Re: JB Hendrson Fabrication Facility
10200 Bell Ave. SE
Traffic Circulation Layout
Architect's Stamp 01-15-2021 (L21-D075)

Based upon the information provided in your submittal received 05-13-2021 the above referenced plan cannot be approved for Building Permit until the following comments are addressed:

AS-101

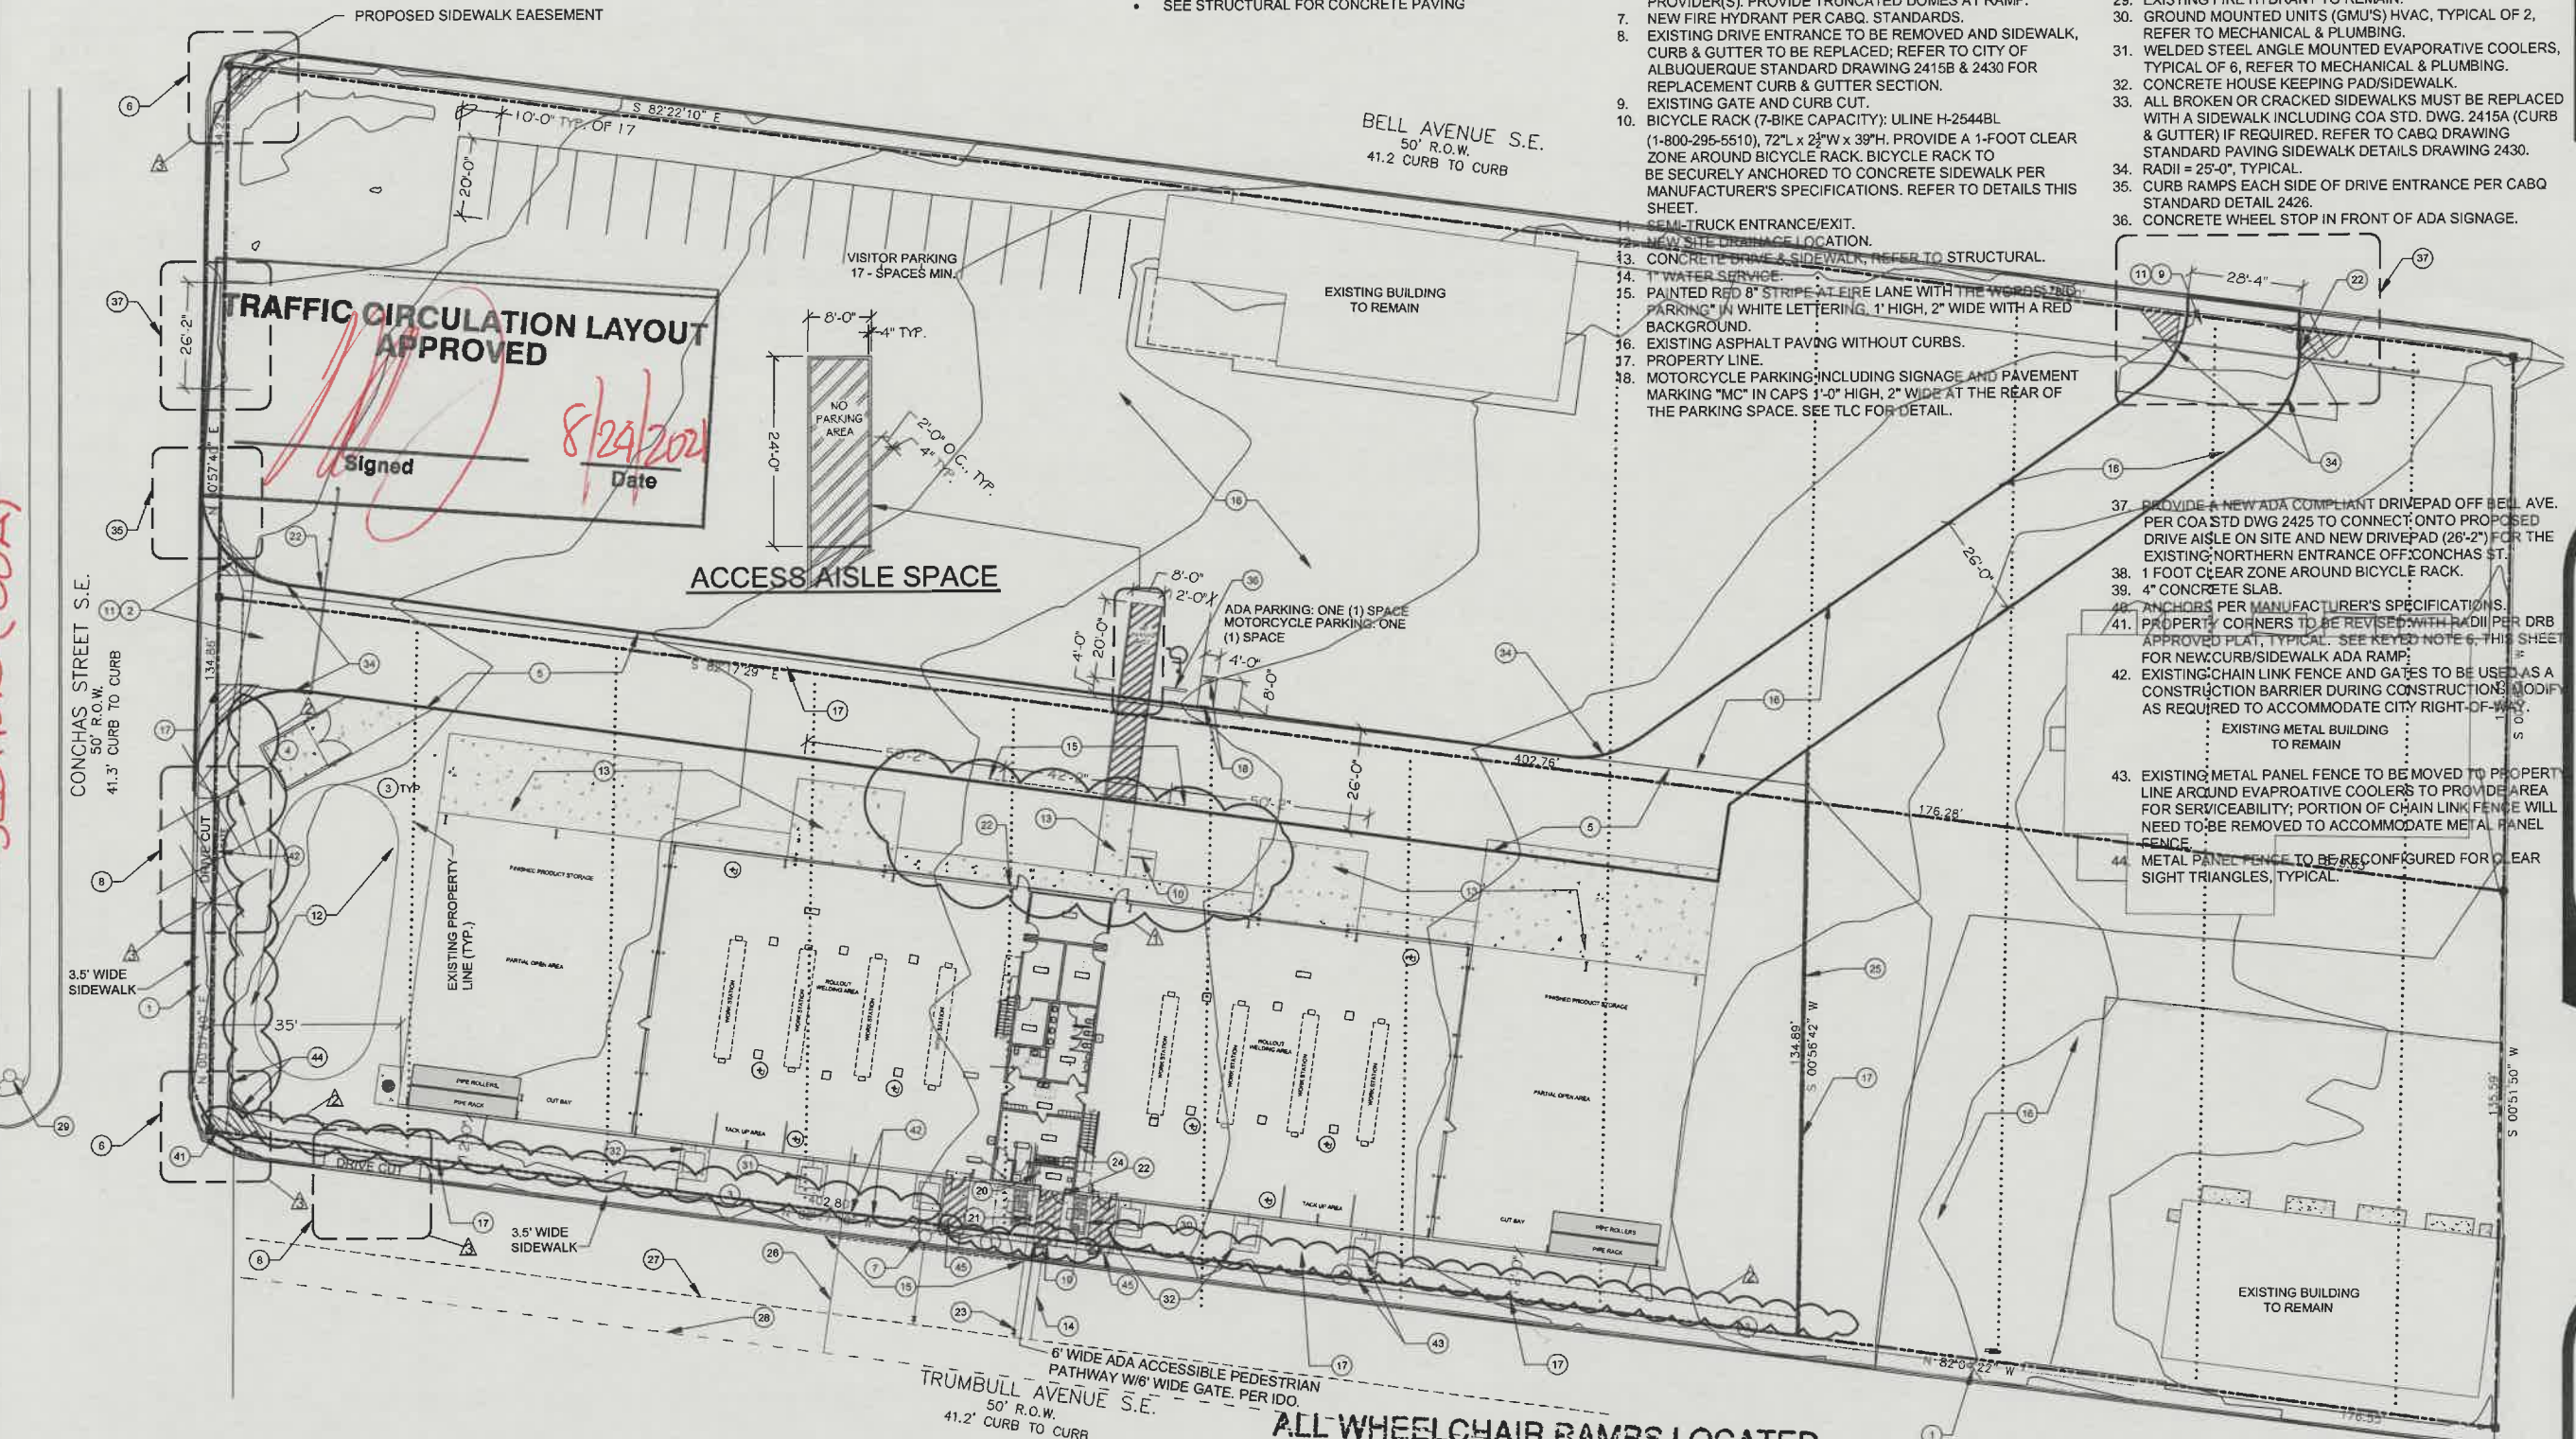
3. **Reiteration of Final C.O. Condition:**
 - **An approved Sidewalk easement in place.**
 - **All mini work order be completed, approved and in place (Key Notes on Sheet AS-101: 14 & 230.**

5. **Key Note 2(AS-101) :** Needs to read COA std dwg **2526 instead of 2525 (SORRY)** for the proposed modified entrance at the 26 ft access off Conchas Sreet.

6. **PLEASE ADDRESS THIS AGAIN: Note needs to be provided for this condition:** Per the IDO, a **6 ft. wide ADA accessible pedestrian pathway** is required from the public sidewalk to the building entrances. **Please clearly show this pathway and provide details (DIMENSION THE PATHWAY)** off Trumbull and if gate exists show a **clear 6 ft width gate.**

7. **Clear Sight Triangle:** See attachment on the correct size and placement of these triangles for driveways and corners. One needs to be added to the 28'-4" driveway on Bell Avenue.

PLAT OF
LOT 10-A, BLOCK 46
SKYLINE HEIGHTS
WITHIN
SECTION 29, T. 10 N., R. 4 E., N.M.P.M.
CITY OF ALBUQUERQUE
BERNALILLO COUNTY, NEW MEXICO
MARCH 2021

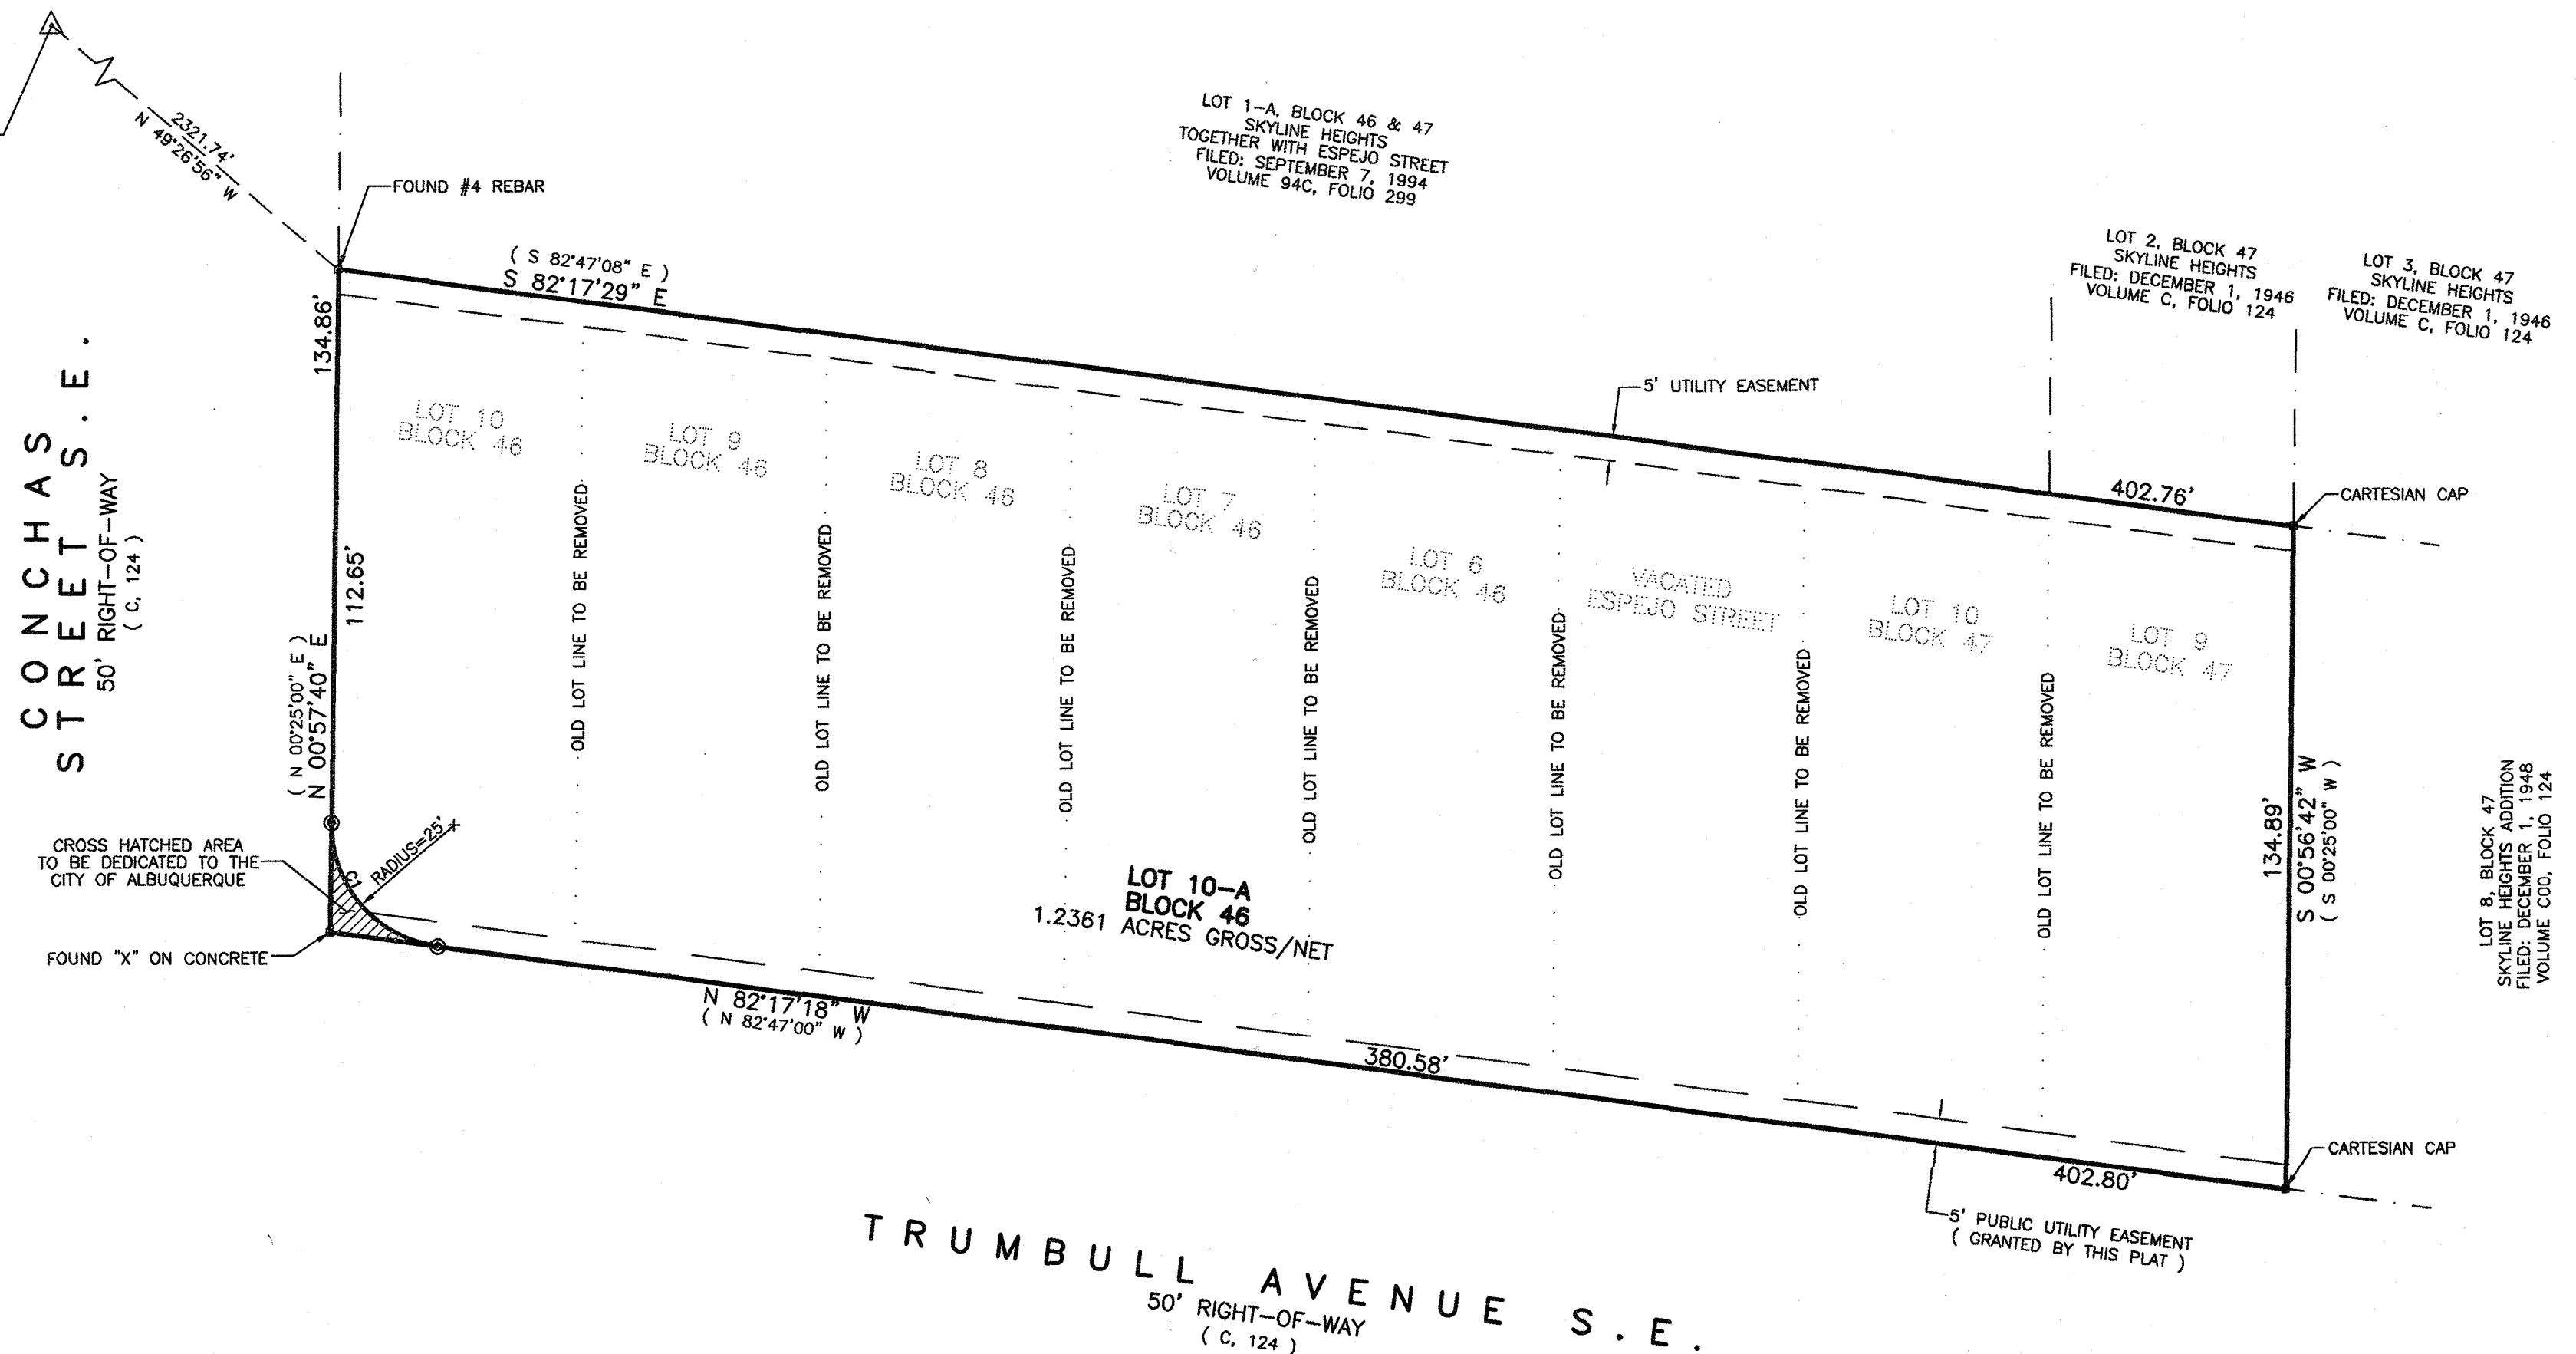
4. Clarify existing property lines and proposed property lines. The property lines appear to be different from AGIS. Please clarify this concern. **Provide approved Plat.**
